From: Paul Beard [REDACTED]
Sent: 26 April 2019 09:07
To: Zac Denton
Subject: CM/13/19/RES

Application Reference:- CM/13/19/RES

Reserved Matters following outline approval CM/37/18/OUT for the redevelopment of site with 2no. 4 bed detached bungalows & associated works Mistletoe Farm, Horsemere Green Lane, Climping BN17 5QZ

Tree Retention & Protection Plan

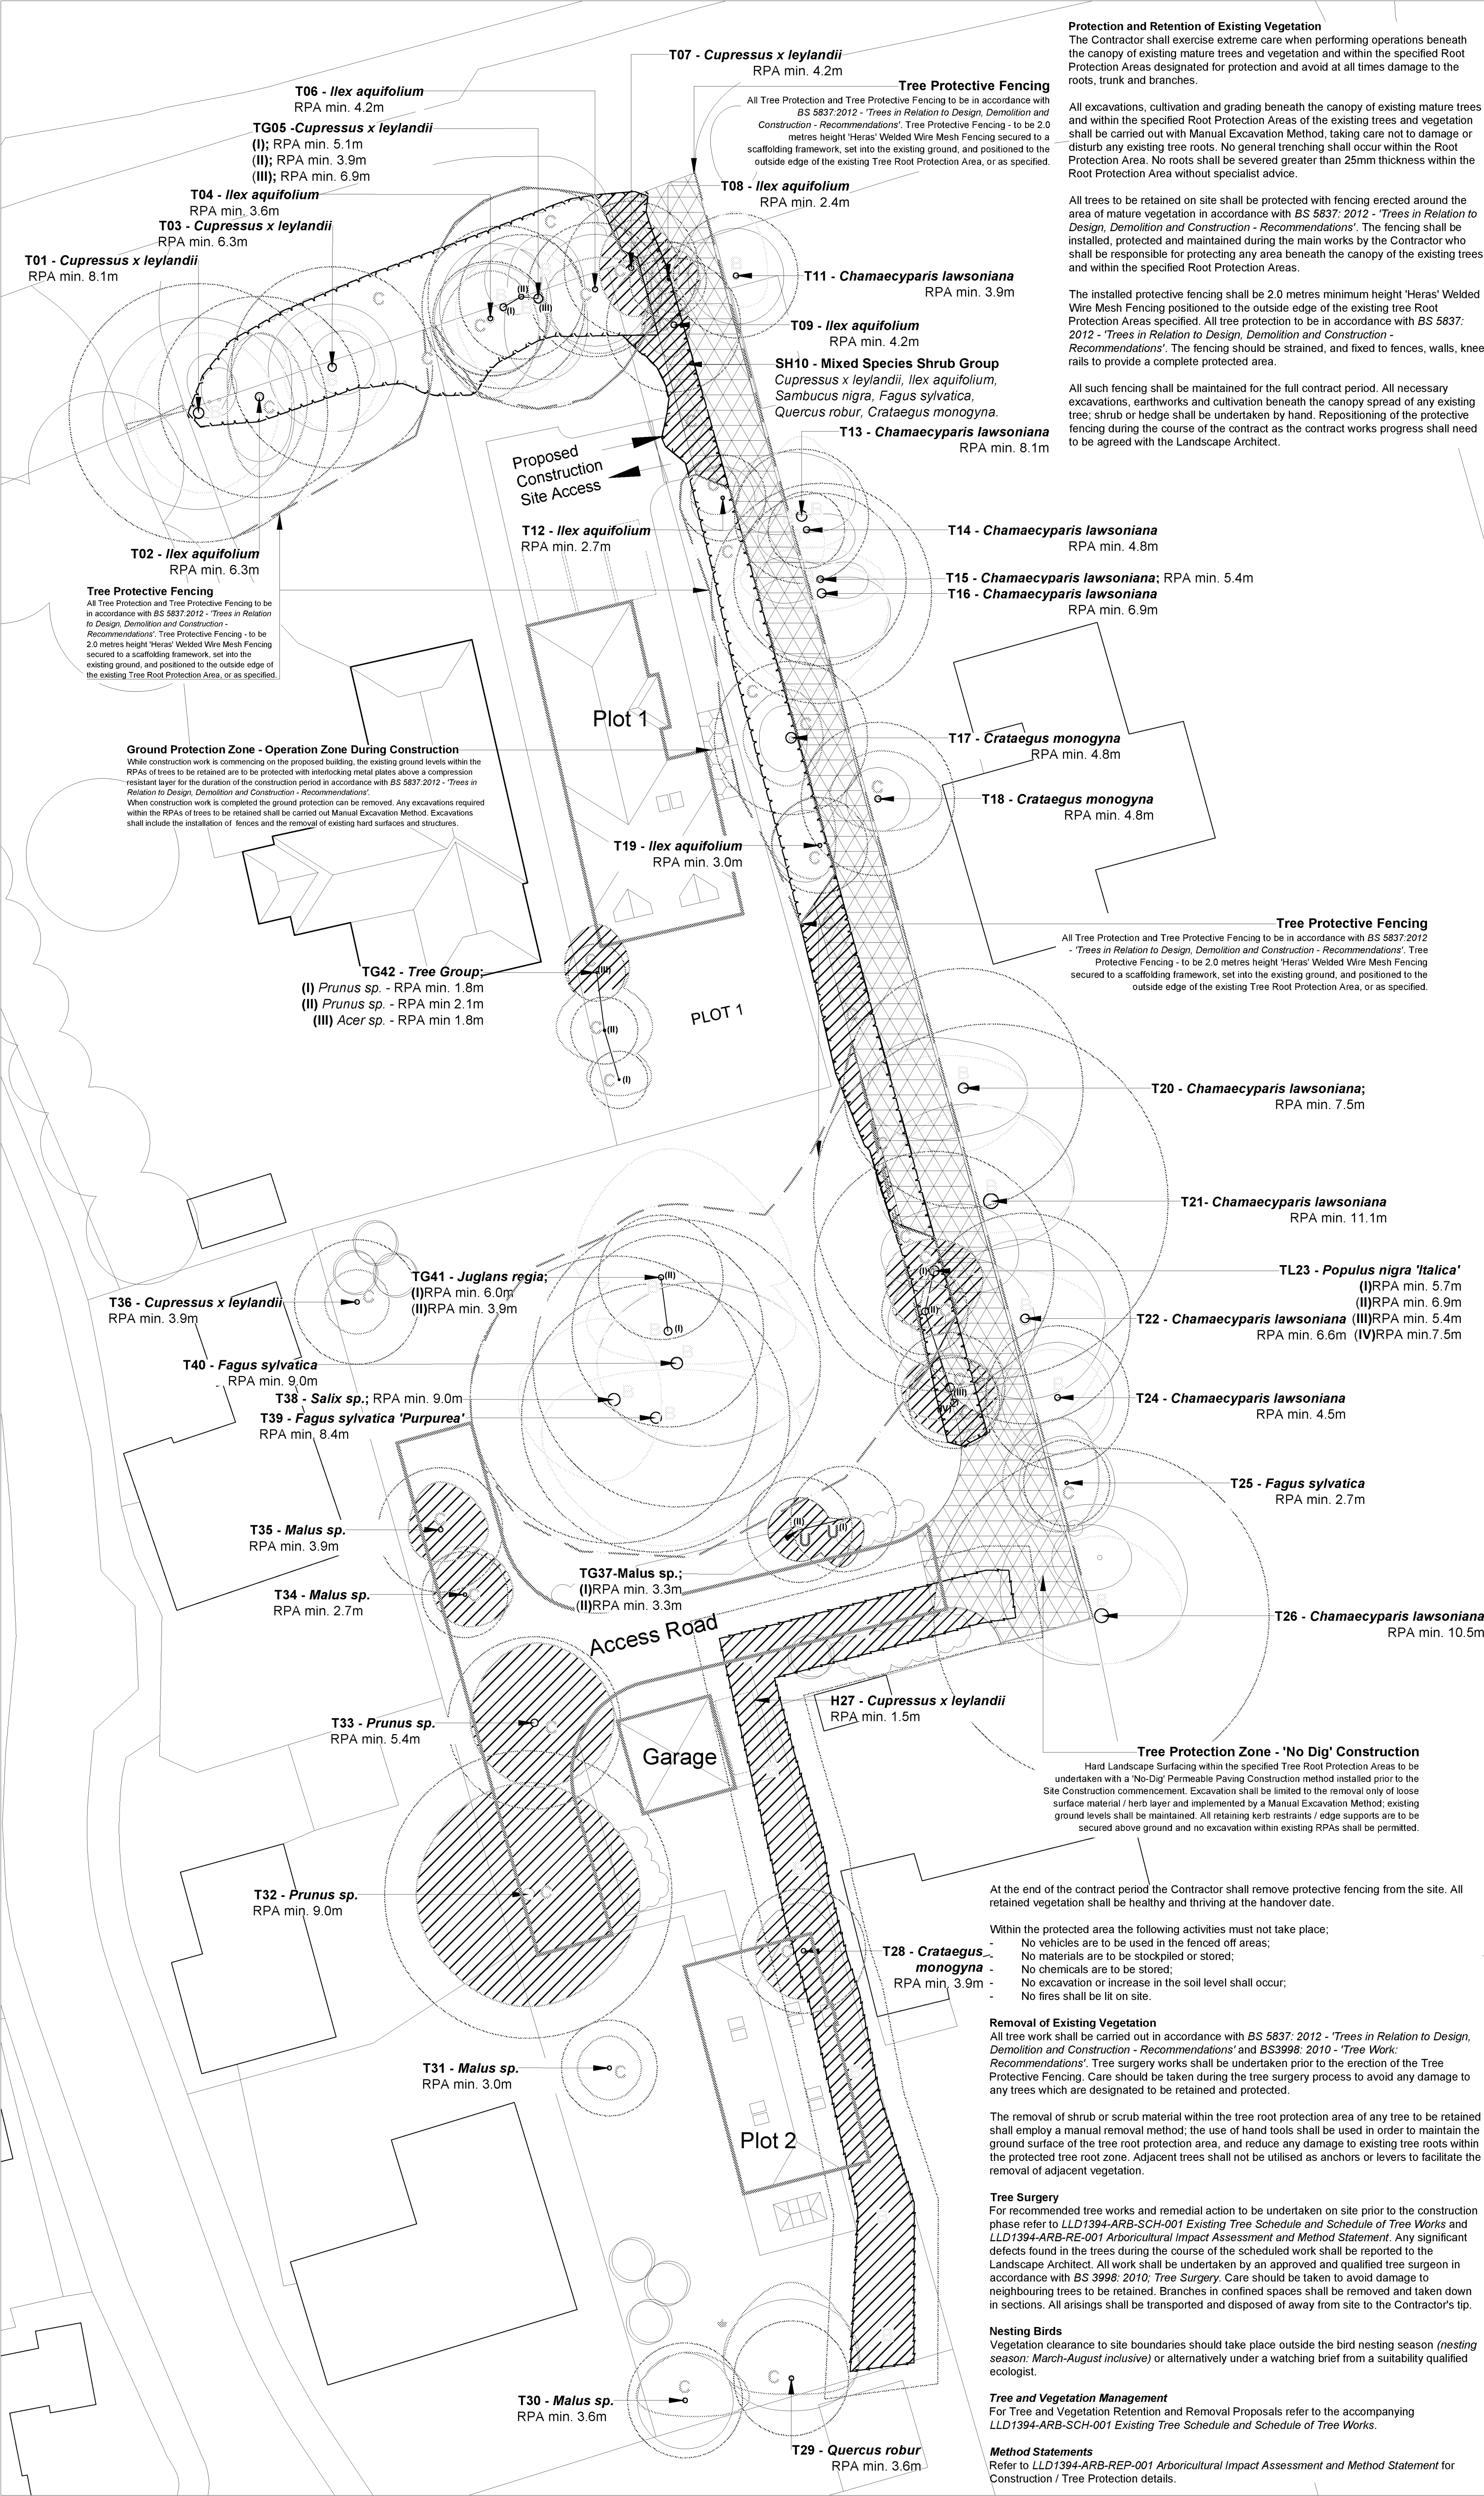
The central space appears to be ill defined and there does not appear to be a detailed long-term Management Plan submitted as part of the Application. It has therefore not been demonstrated that the visual amenity and biodiversity interest would be conserved over time, nor how the TPO beech tree would be managed and maintained.

The proposal does not accord with Policy ENV DM4 because proper provision has not been made for the management of trees on site - in particular a Management Plan has not been provided to ensure that trees - especially the TPO beech tree - are appropriately maintained in the future.
